16 December 2025

Your Ref: SSD-83112728

Major Projects New Request for Advice - Residential Flat Building – 2 Fishburn Crescent - SSD-83112728

Tree Management Plan Sheet 2 of 2

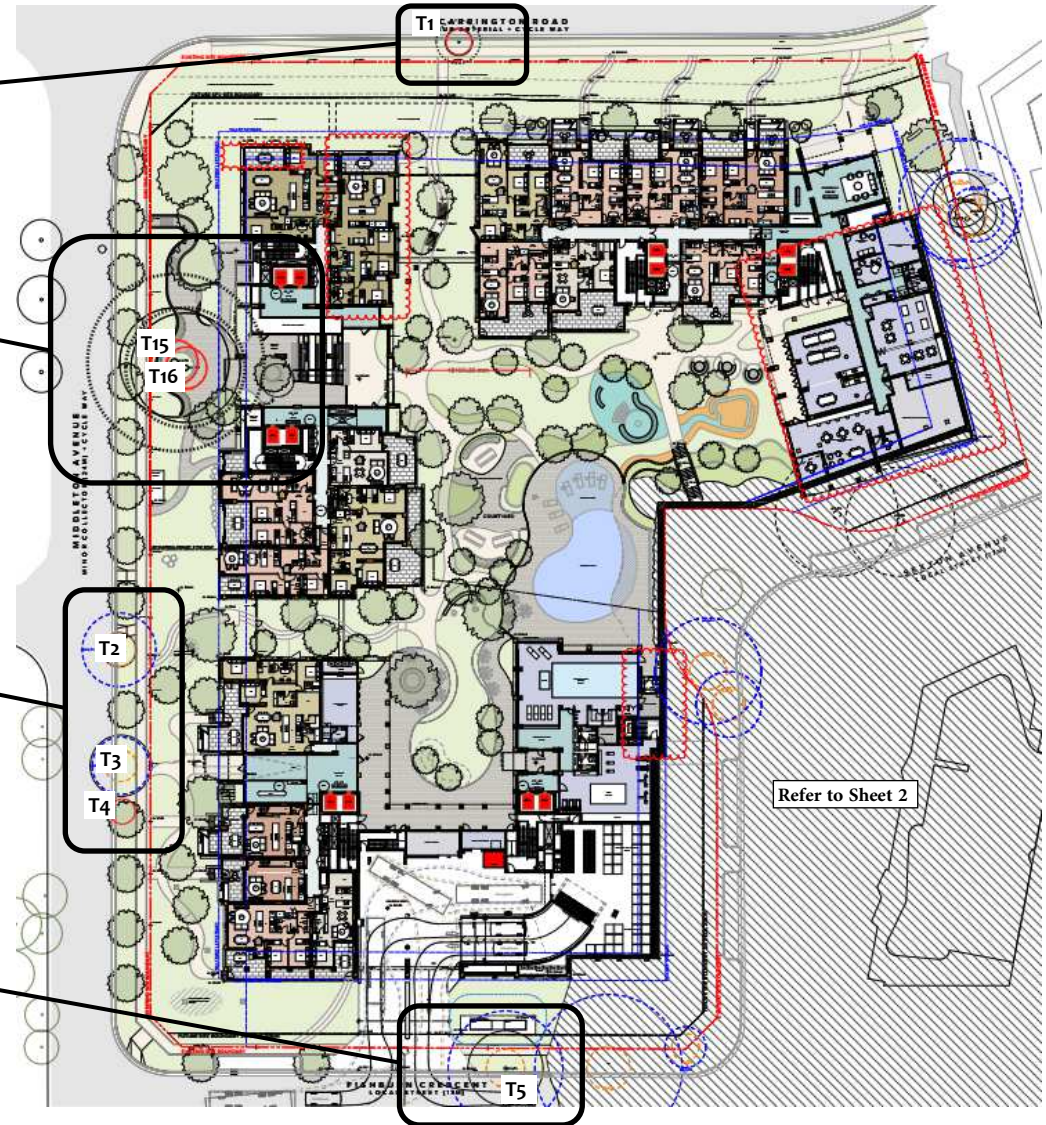
There are significant concerns regarding the existing trees on site, particularly Tree 13 and Tree 14. Both trees are highly significant, forming part of an Endangered Ecological Community (EEC) and are protected under the *Threatened Species Conservation Act 1995*.

As discussed in the pre-meeting, these two *Eucalyptus tereticornis* trees are to be retained. Removal to accommodate the proposed design is considered unreasonable.

The design should avoid these trees entirely. Any encroachment within the Notional Root Zone (NRZ) must either be eliminated or assessed by a qualified consulting arborist to ensure ongoing viability.

- **Tree 13**

- NRZ Incursion: **12.4%** from the proposed basement and building footprint.
- Assessment: This level of impact may be tolerated with appropriate management by the appointed arborist.
- Recommendation: Any additional soil disturbance within the NRZ must be redesigned and avoided.

- **Tree 14**

- NRZ Incursion: **18.3%** from earthworks and public domain/civil design.
- Assessment: Further clarification is required to determine whether these impacts would allow the tree to remain viable.
- Recommendation: Detailed arborist advice is required before proceeding.

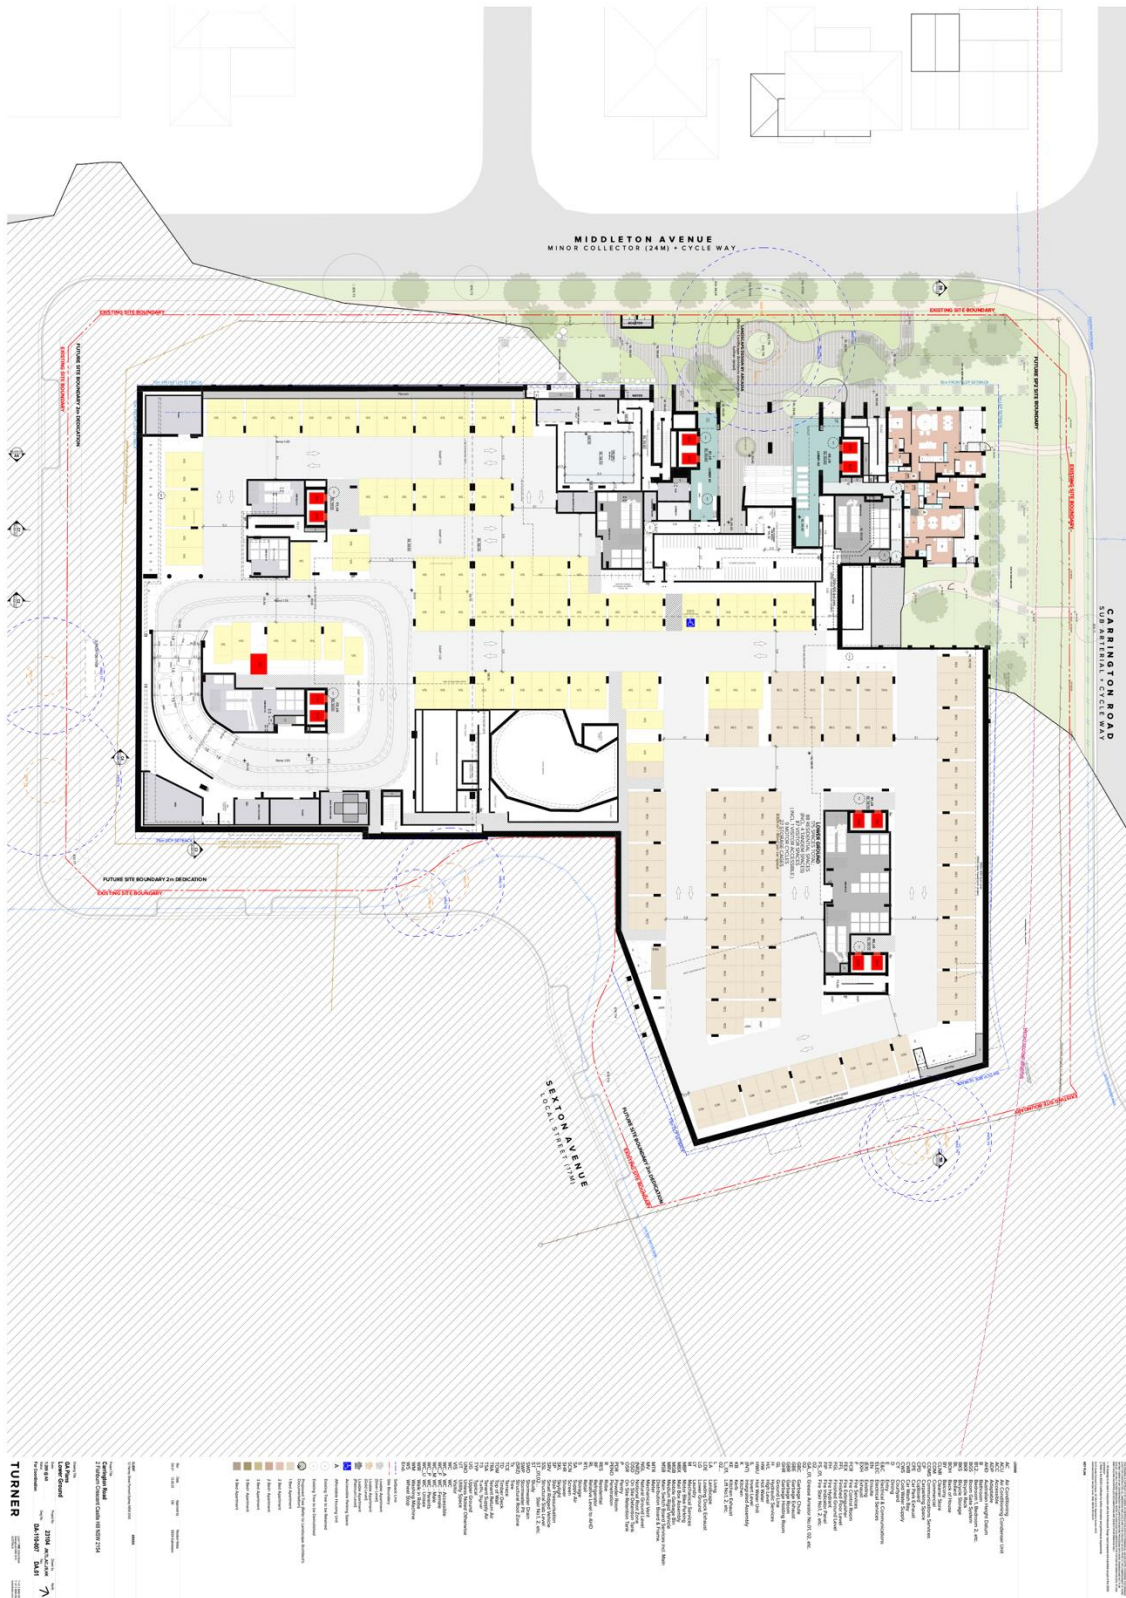
- Separate FOGO bin rooms must be provided adjacent to residential lift cores on lower ground level.
- Bulky waste room needs to be of minimum size of 36m² for this development, current plans show 19m².
- Garbage must be compacted at a ratio of 2:1
- Garbage and recycle will be collected twice weekly, FOGO weekly. Bins for the development will be,
 - Garbage- 12 x 1100lt bins collected twice weekly compacted at a ratio of 2:1
 - Recycle – 12 x 1100lt bins collected twice weekly, no compaction
 - FOGO- 23 x 240lt bins collected weekly
